## **Development Facilitation Team (DFT) – Review Comments**

**Project No: PR-2020-004596      Date: 03/27/2024      Agenda Item: #3 Zone Atlas Page: D-10**

**Request: PRELIMINARY PLAT EXTENSION FOR 30 ACRE DEVELOPMENT TO INCLUDE 162 TOWNHOME LOTS, 1 MULTI FAMILY RESIDENTIAL LOT WITH 175 APARTMENT UNITS AND 1 COMMERCIAL LOT WITH A TOTAL OF APPROXIMATELY 21, 955 SQUARE FEET OF BUILDING SPACE. PRELIMINARY PLAT ORIGINALLY APPROVED MARCH 29, 2023 BY THE DRB.**

**Application For: SD-2024-00045-EXTENSION OF PRELIMINARY PLAT (DHO)**

SEE SHEET 3  
 MATCHLINE

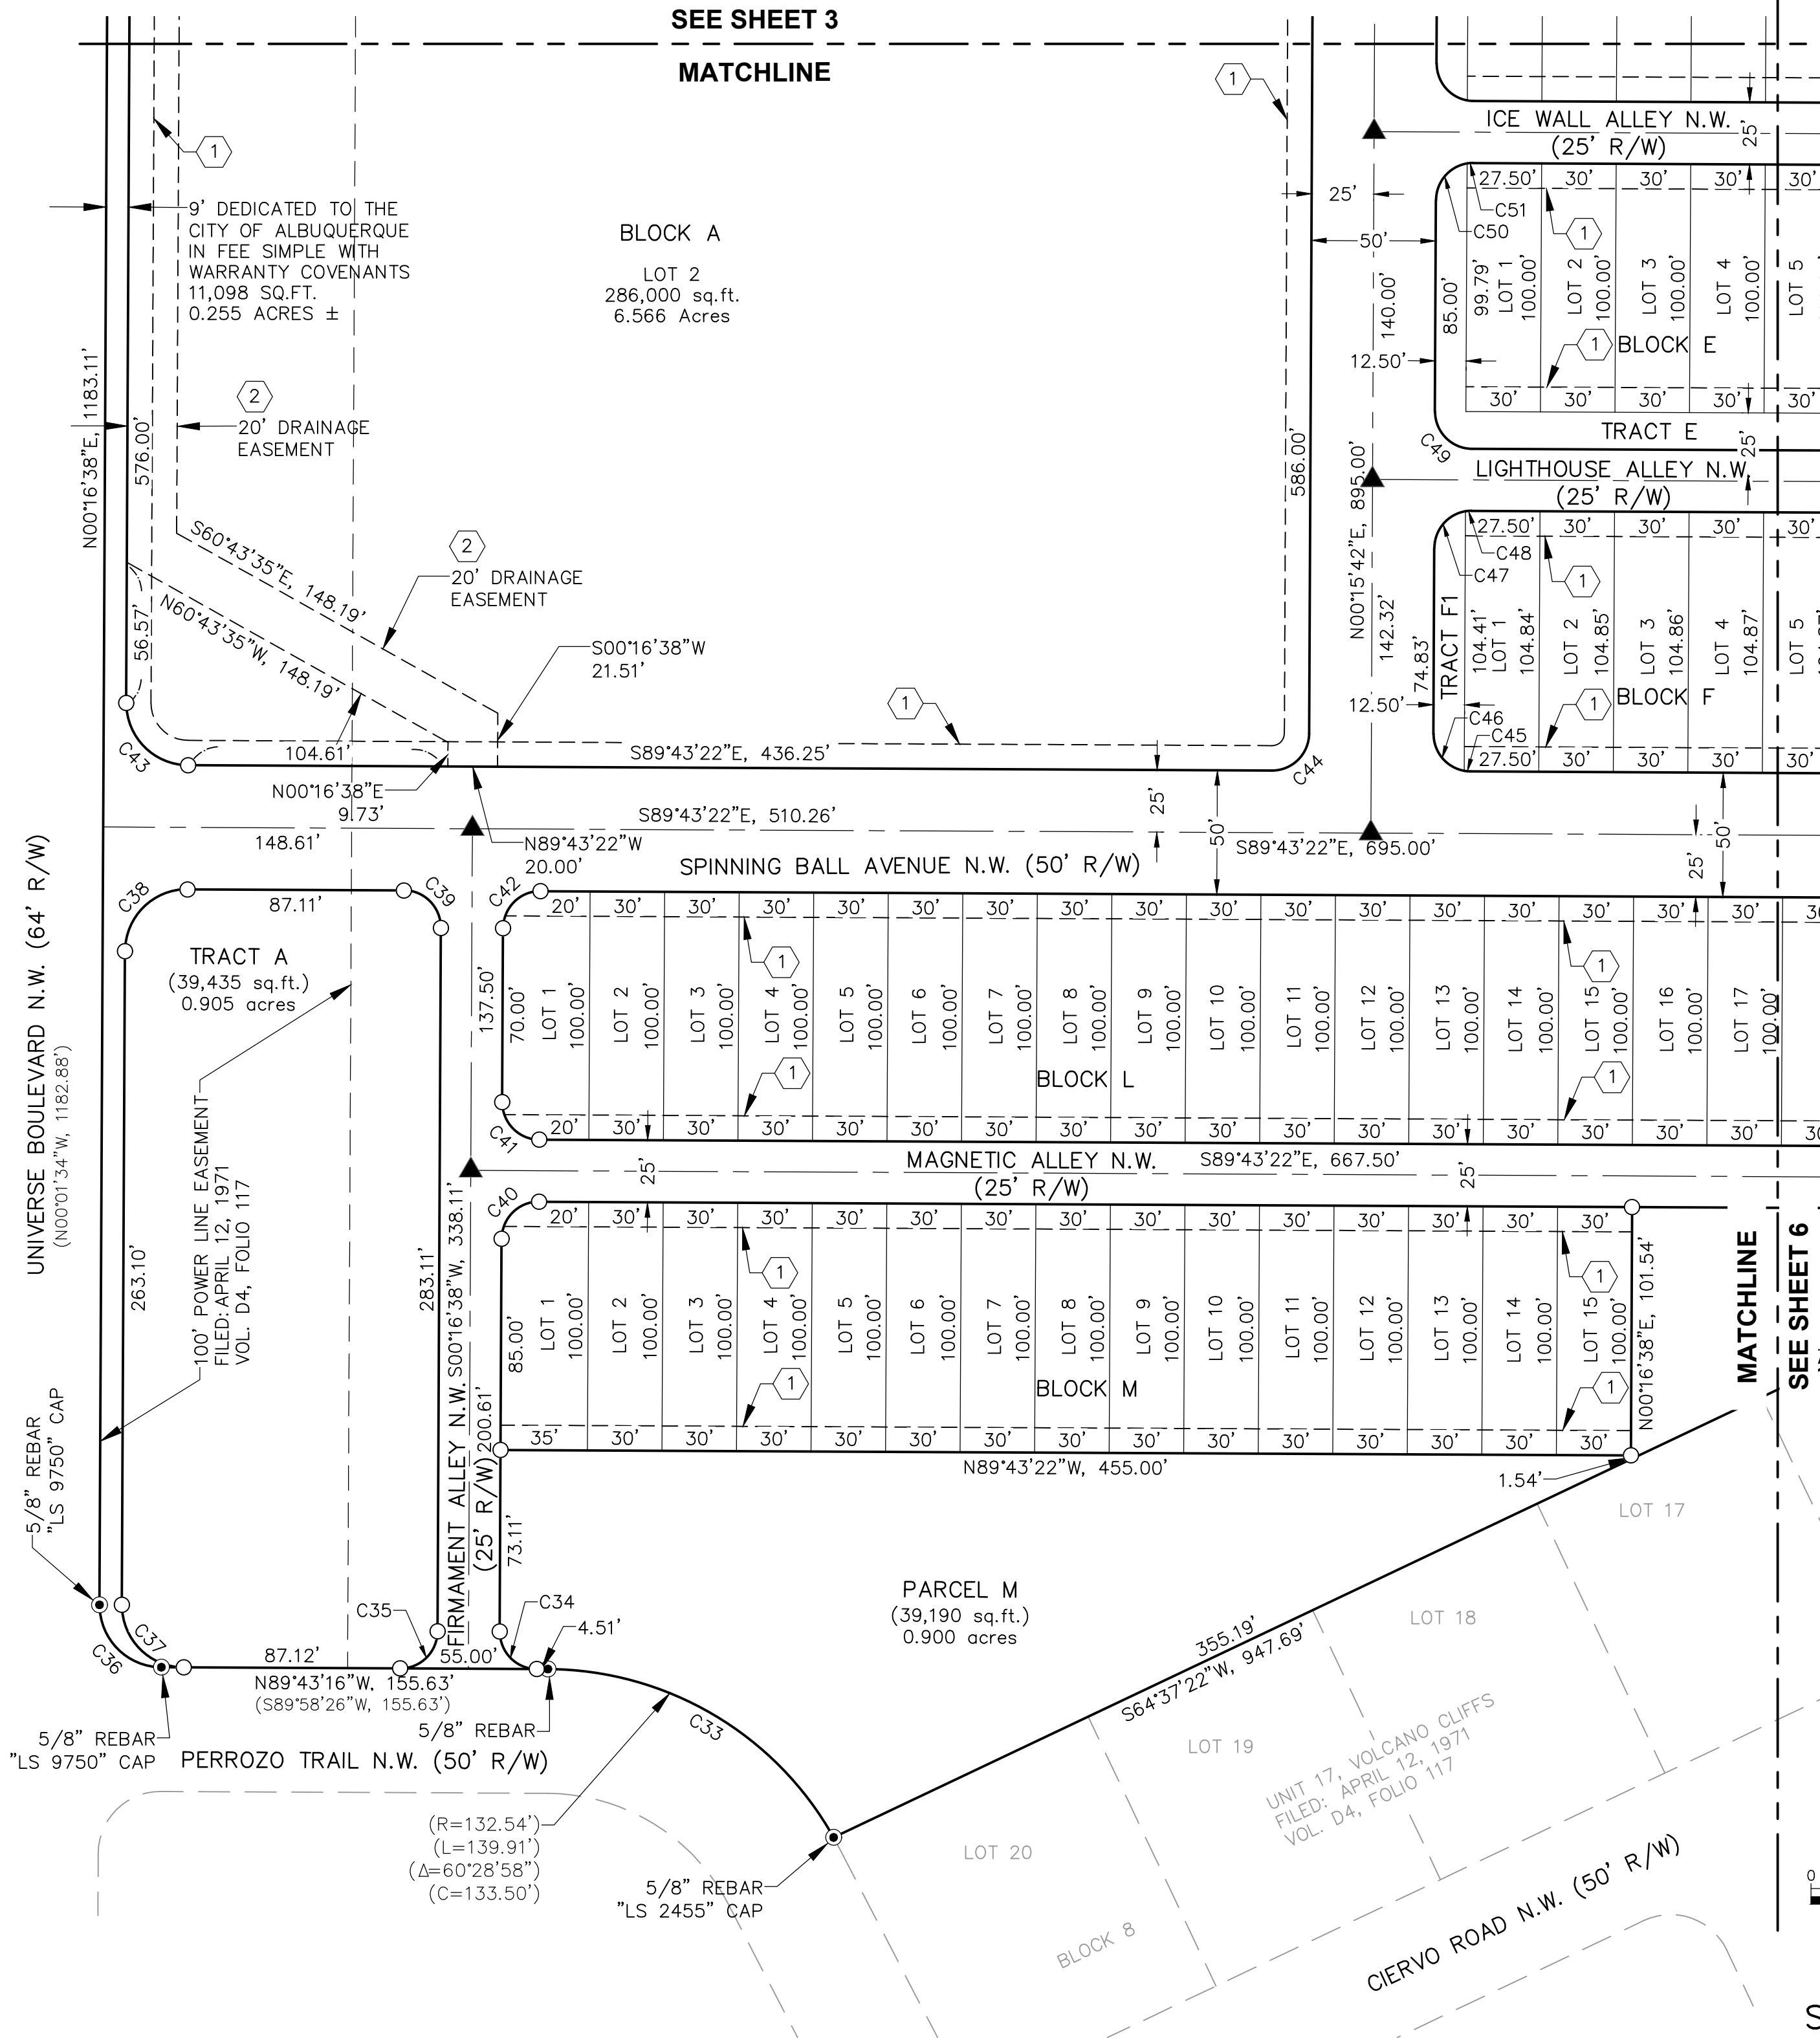
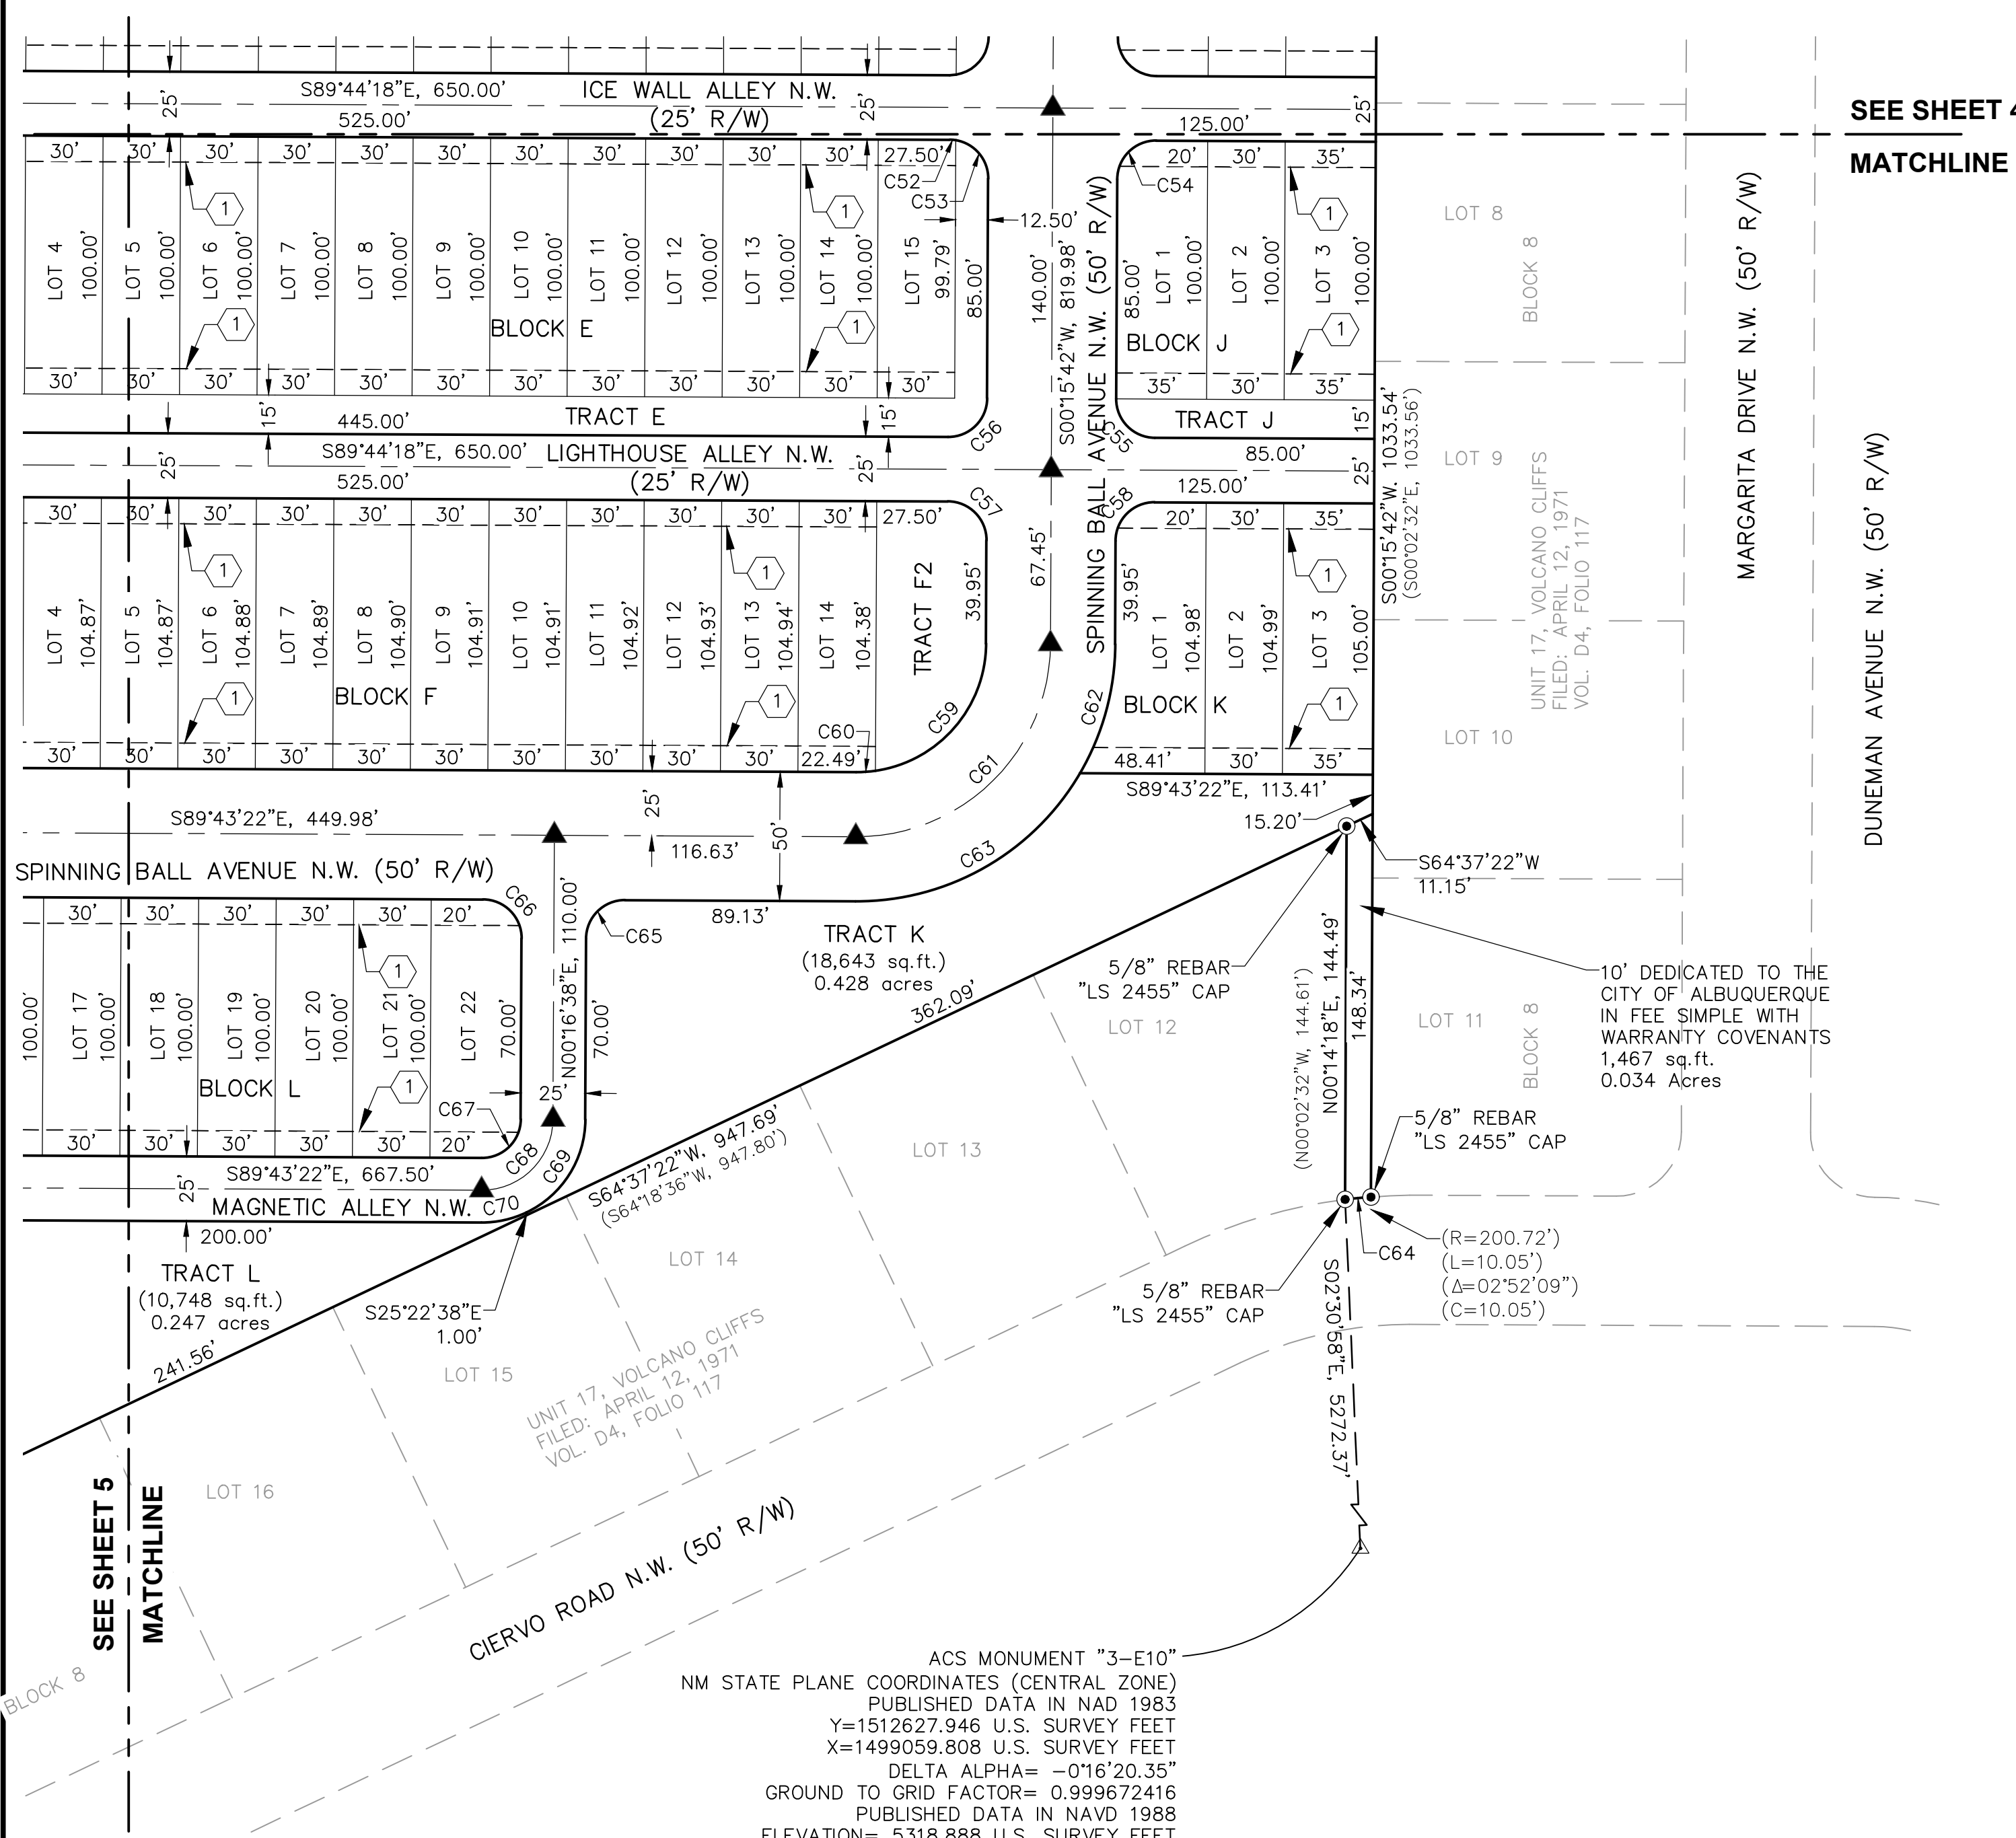
- Please confirm for the DHO that this request has no changes from the original DRB approval including any changes to lot numbers, sizes, and/or configurations, as well as any changes to easements and/or notes depicted on the original Preliminary Plat.
